**RE: Response to Submissions – State Significant Development (15_7064)
175-177 Cleveland Street and 1-5 Woodburn Street, Redfern**

REVIEW OF RESPONSE TO SUBMISSIONS

**CROSS VENTILATION STUDY**

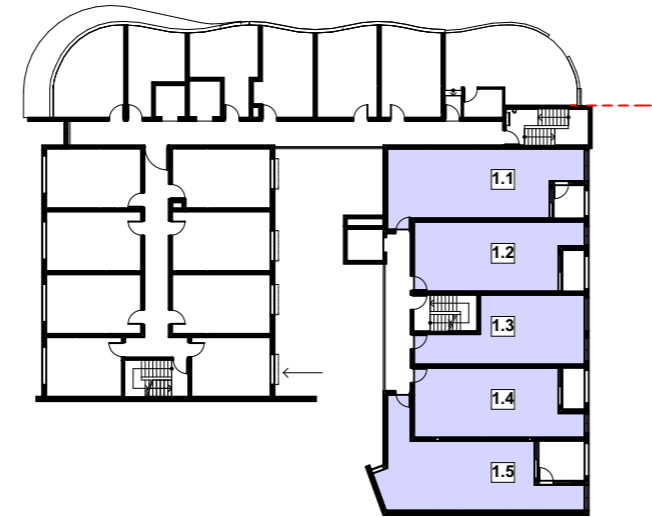
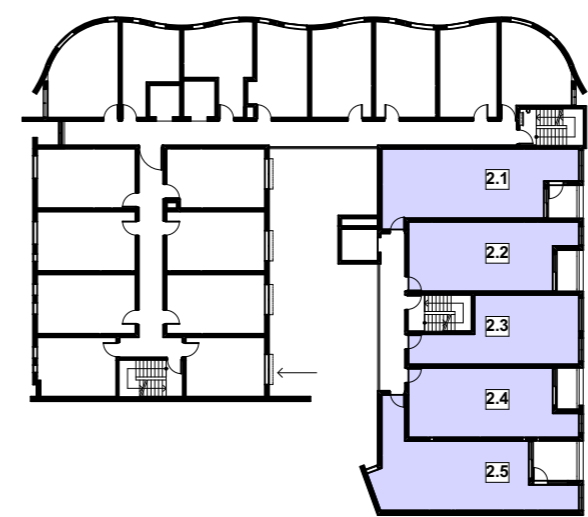
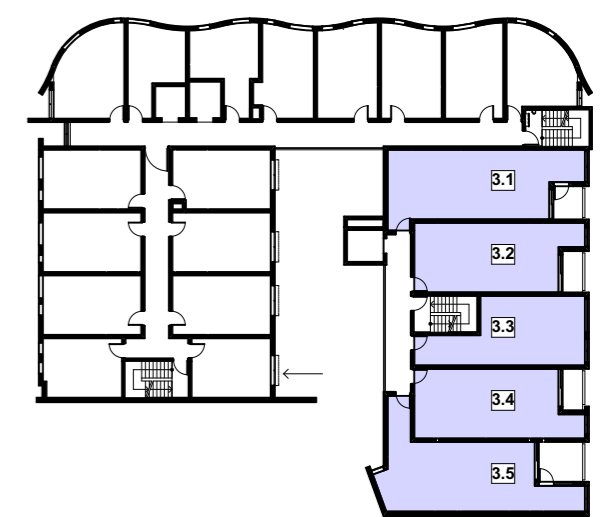
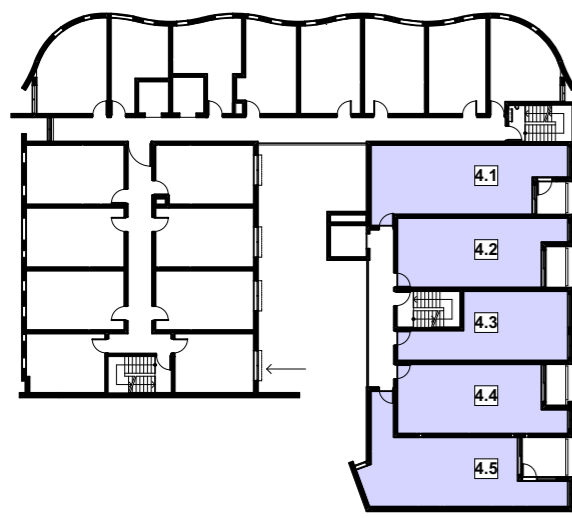
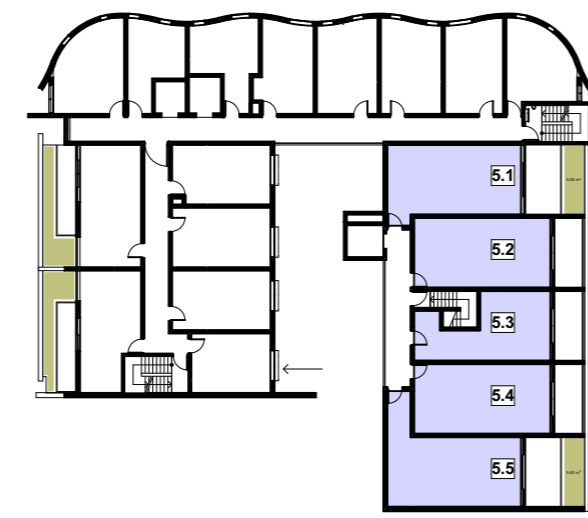
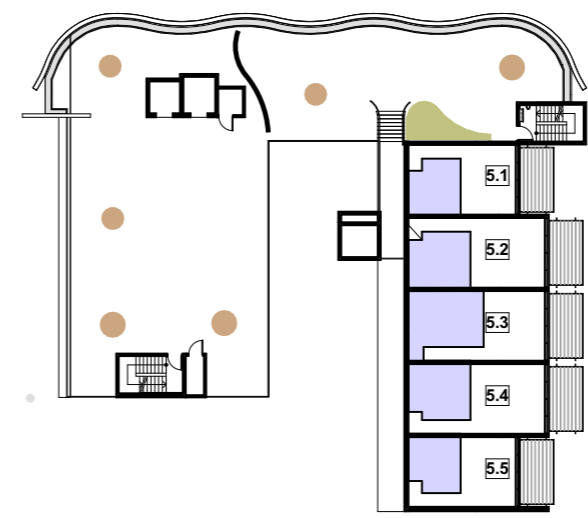
Issue	Applicant's Response	Issue Addressed?	City's Contention
<ul style="list-style-type: none"> It is unclear from the drawings the type of windows that are proposed and what the effective openable area is. <p>More information is required to accurately demonstrate the level of compliance with the natural cross ventilation requirements of the ADG.</p>	<p>strictly compliant with the ADG (i.e. 2.5% opening on either side of the apartment).</p> <p>The proposed approach towards cross ventilation represents a compliant outcome which satisfies Objective 4C1 of the ADG for the number of apartments with natural cross ventilation to be maximised to create a comfortable indoor environment for residents.</p>		<p><i>windows such as casement, awning and hopper windows may measure the diagonal plane from the sash to the jamb and add the triangles at either end up to a total area of the window opening in the wall. Obstructions within 2m of a window reduce the effective openable area as measured in elevation. Fly screens and security screens will reduce the effective openable area by half.</i></p> <p>There is insufficient information to determine the effective openable area, and thus if the required level of natural ventilation is achieved.</p> <p>We note that two of the ground level apartments are capable of providing cross ventilation but there will be a conflict between the desire for fresh air through cross ventilation and the perceived privacy and safety and security of the residents.</p> <p>While Apartments 2.4, 3.4, 4.4, and 5.3 are considered as dual aspect apartments, the air flow</p>

Issue	Applicant's Response	Issue Addressed?	City's Contention
			<p>path between the living room windows and the bedroom window facing the courtyard has an obstructed airflow path. Although there is a secondary window provided to the entry corridor, the ADG requires for the air flow to be provided to n-1 bedrooms, where n is the number of bedrooms. These apartments are 2 bedroom apartments and do not fulfil the definition of natural cross ventilation in the ADG:</p> <p><i>Natural ventilation which allows air to flow between positive pressure on the windward side of the building to the negative pressure on the leeward side of the building providing a greater degree of comfort and amenity for occupants. The connection between these windows must provide a clear, unobstructed air flow path. For an apartment to be considered cross ventilated, the majority of the primary living space and n-1 bedrooms (where n is the number of bedrooms) should be on a ventilation path.</i></p>
